RE: Advice on Assessment - SSD-11826681 - Advice on Assessment - HVO North Open Cut Coal Continuation Project

TfNSW has reviewed the Response to Supplementary Advice by EMM dated 1/3/2024, including a Strategic Concept Intersection sketch of Golden Highway / Comleroi Road and provides the following comments to assist the Department in finalising this assessment:

ATTACHMENT A

HVOP-WSP-55.01.02.02-TR-0002

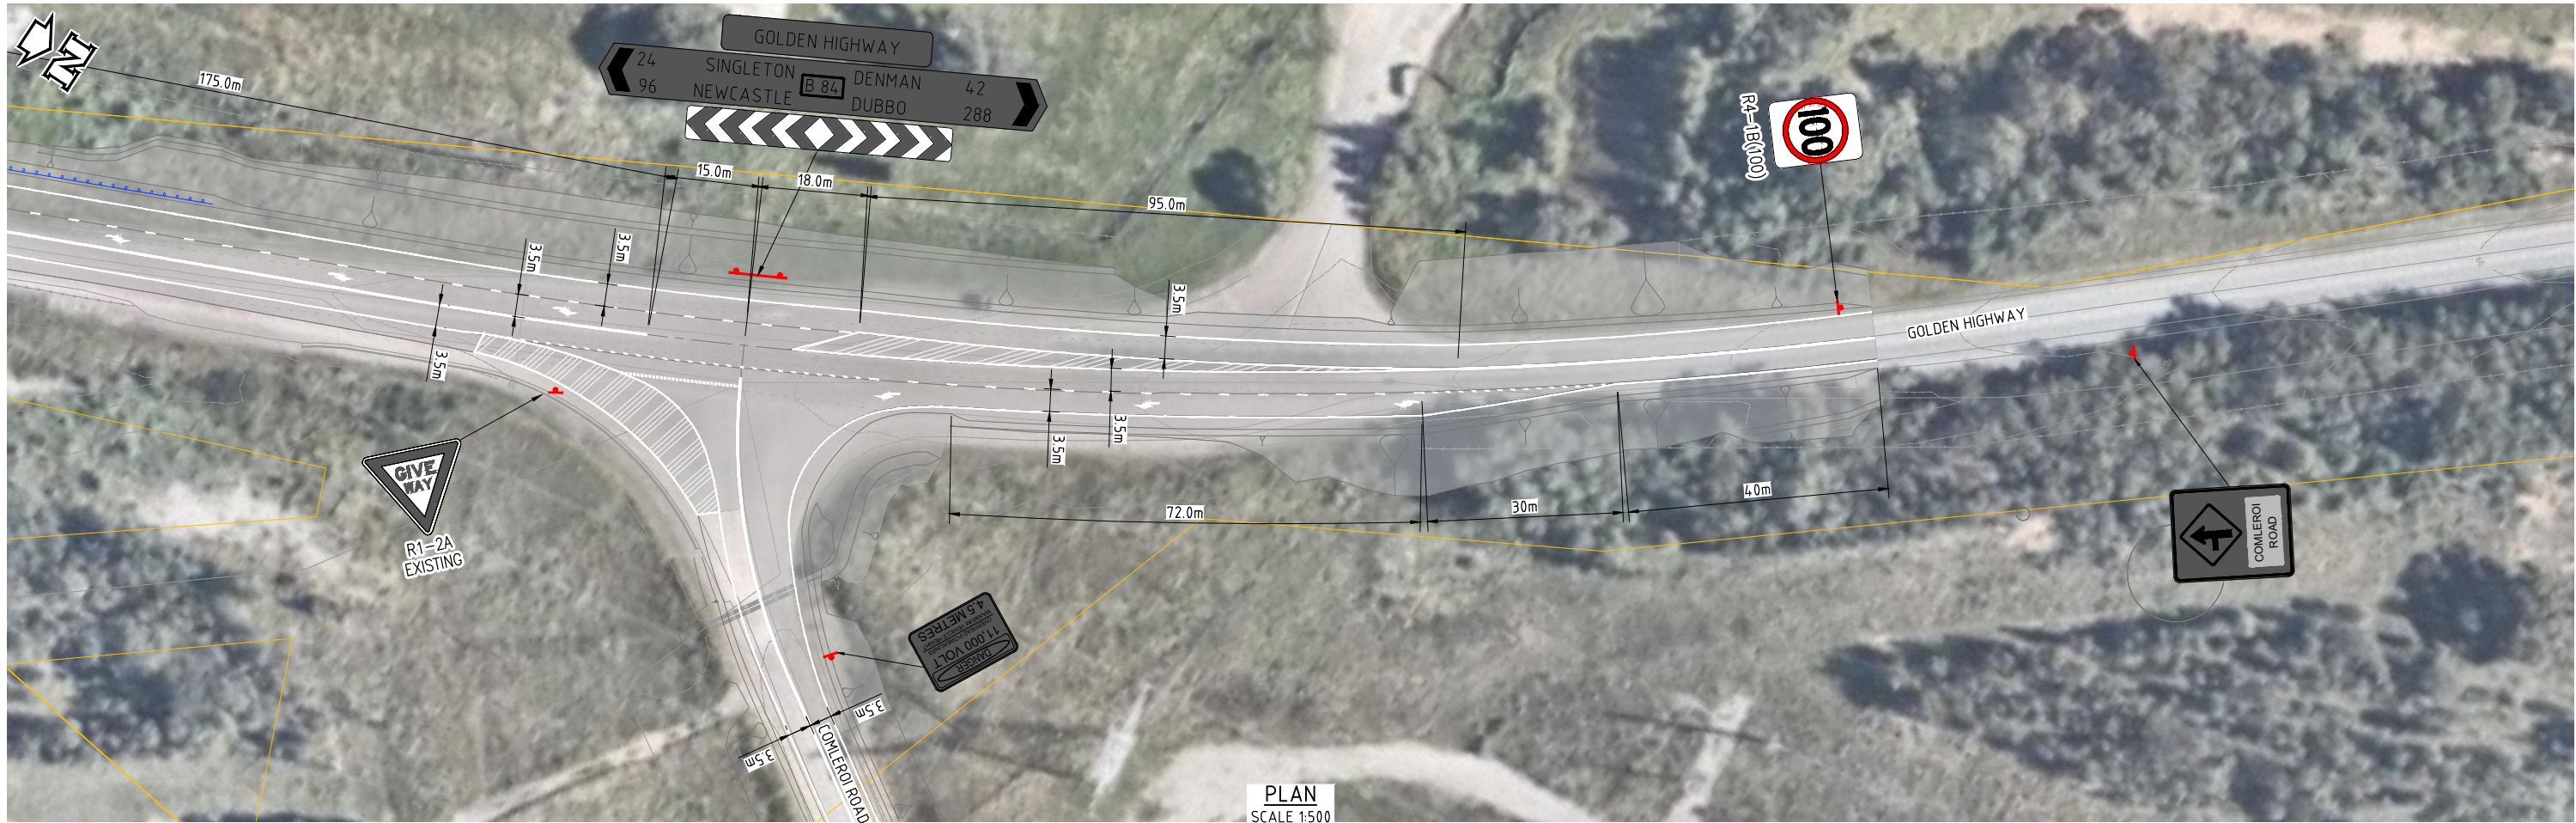
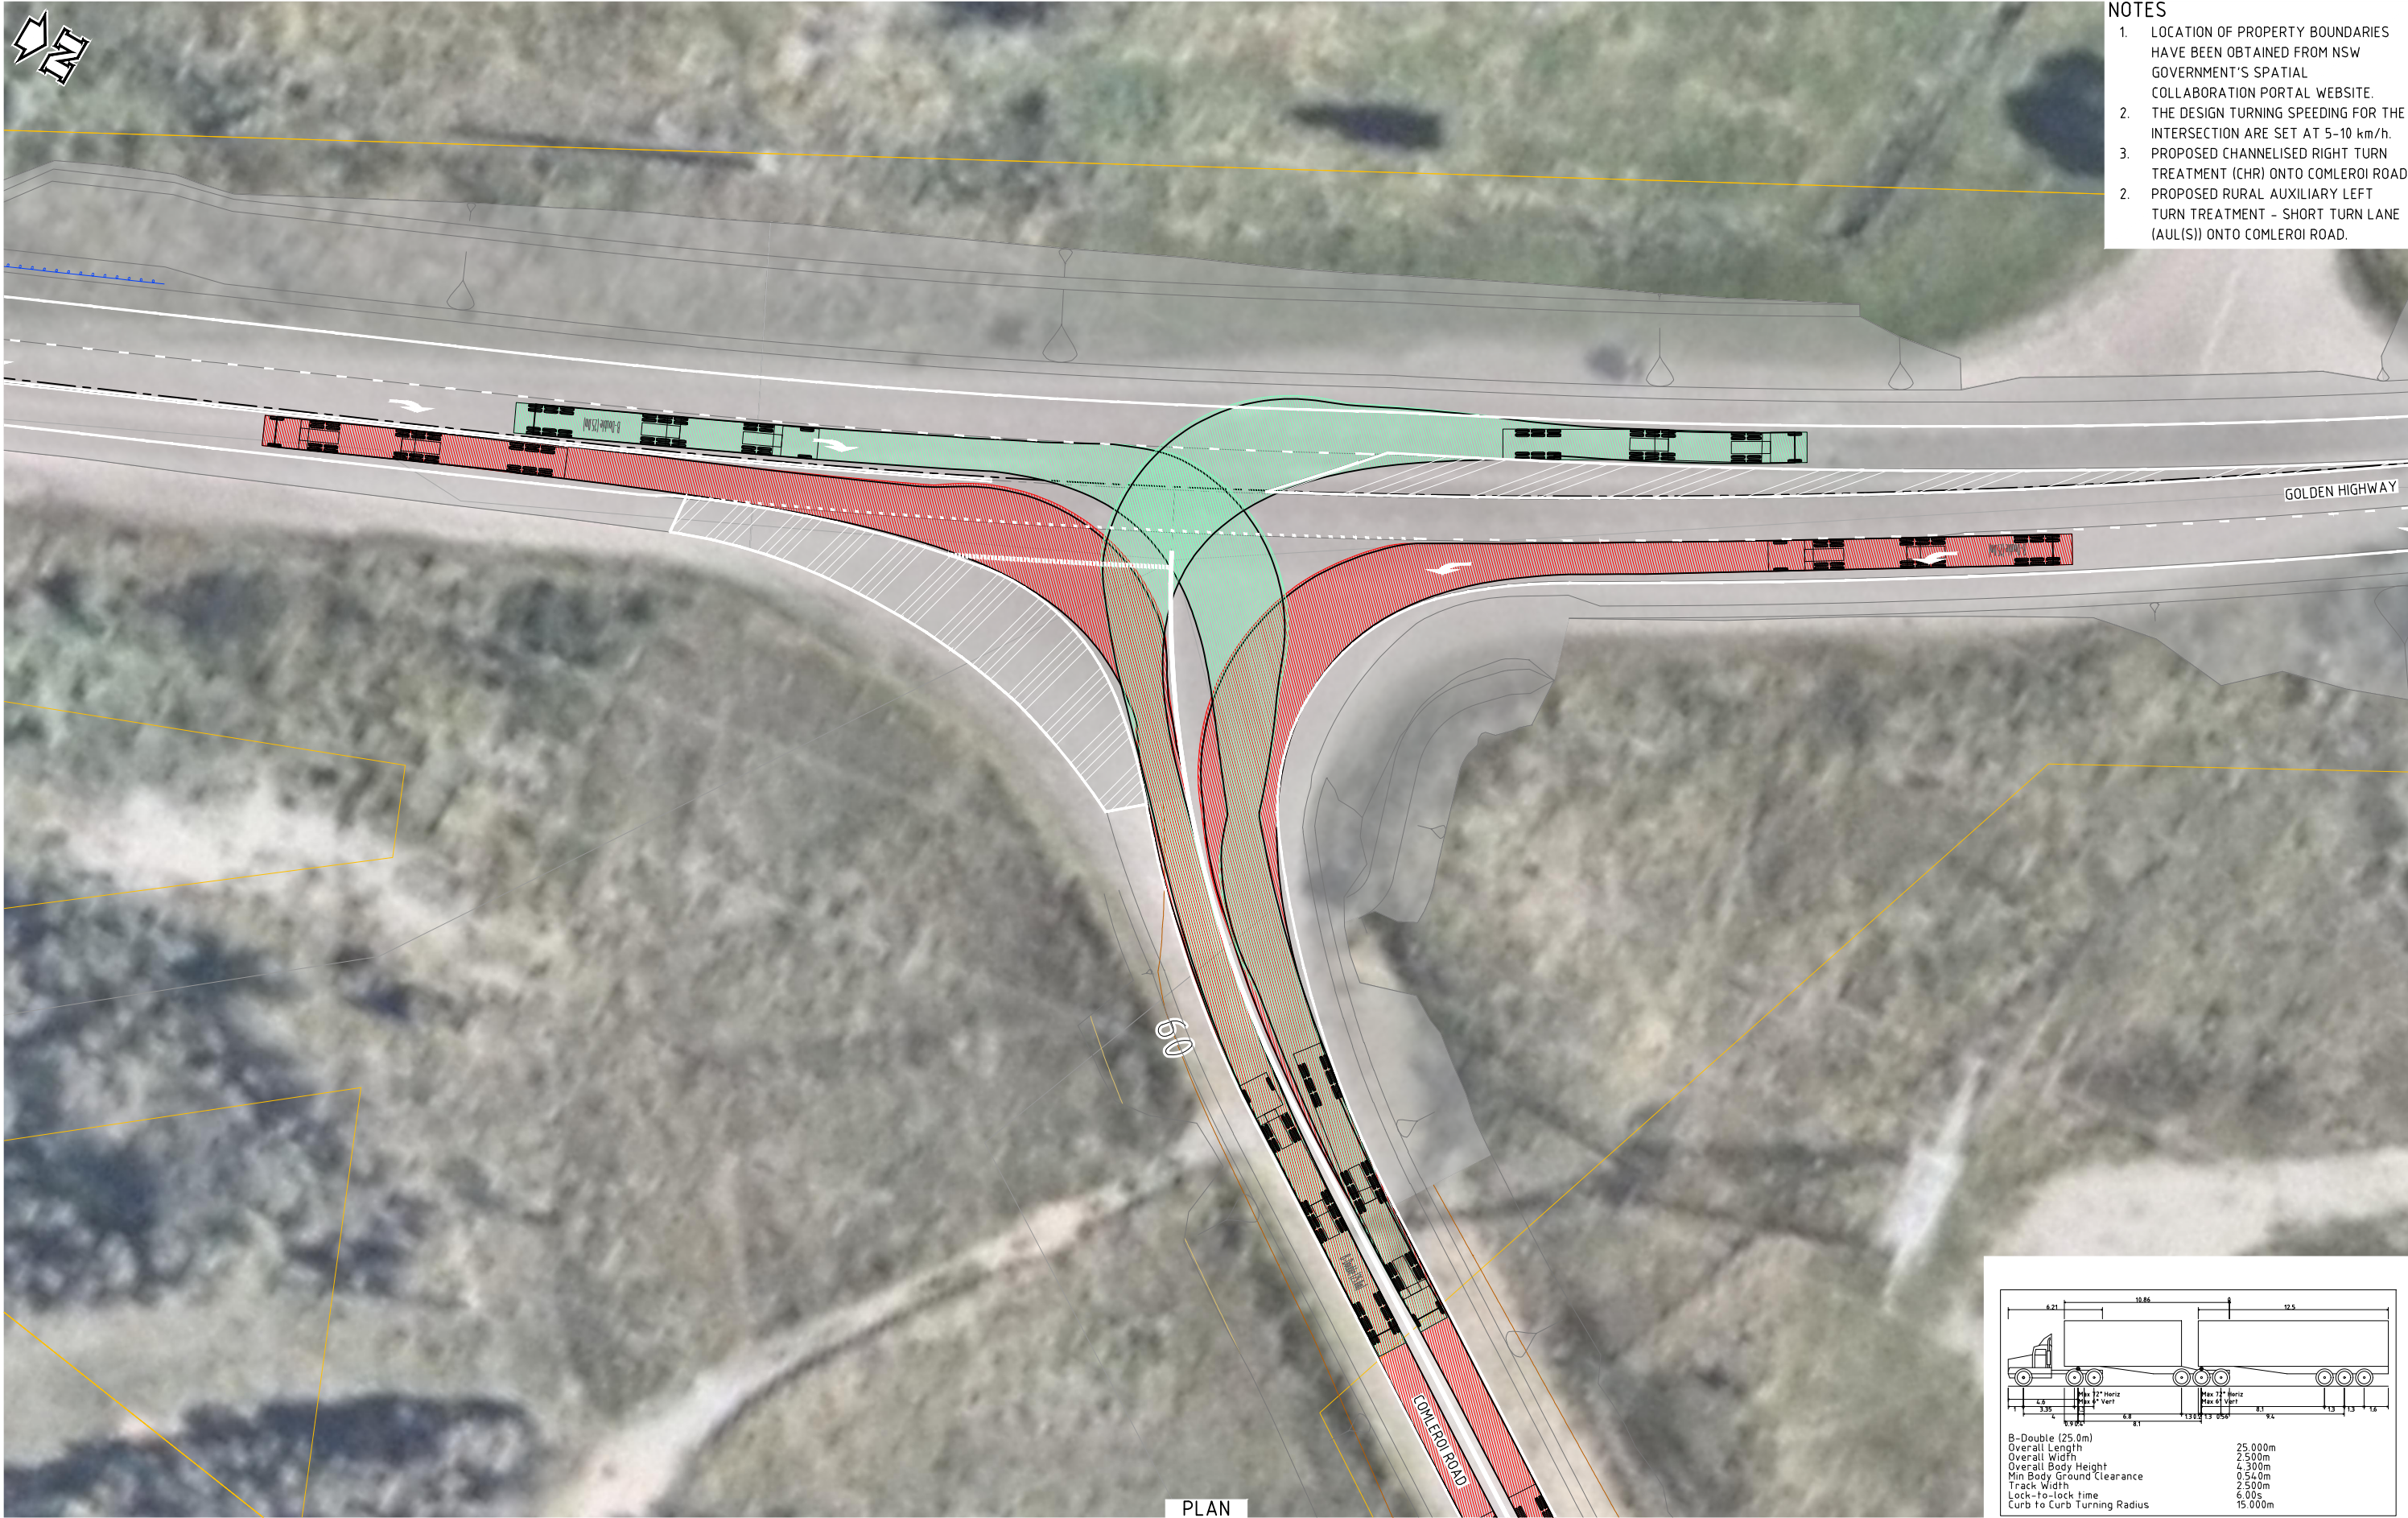
- The plans didn't show any Horizontal geometry, Vertical geometry, or a typical section.
- The design speed was assumed as 110km/hr, the CHR conformed to figure 7.3 from AGRD P4A.

- Plans note AUL(s) and report section 2.7 notes a AUL. Was the left turn supposed to be a AUL or AUL(s)? Any treatment should be designed as an offset left arrangement.

- The gated entry opposite Comleroi road has had its deceleration lane removed. If this access remains open, then it should still have a deceleration lane equivalent to the existing. Otherwise, it should be closed, and the pavement removed.

- The new barrier at the Redbank Creek culvert will need to conform to TfNSW standard. *TS 00028_7.00_Accepted Road Safety Barrier Systems and Devices.pdf*

- The Chevron on Comleroi road intersection should curve around the corner and the merge arrow should be removed. Refer *TS 05462.8_0.00_Delineation Part 8 Diagonal and chevron markings.pdf*
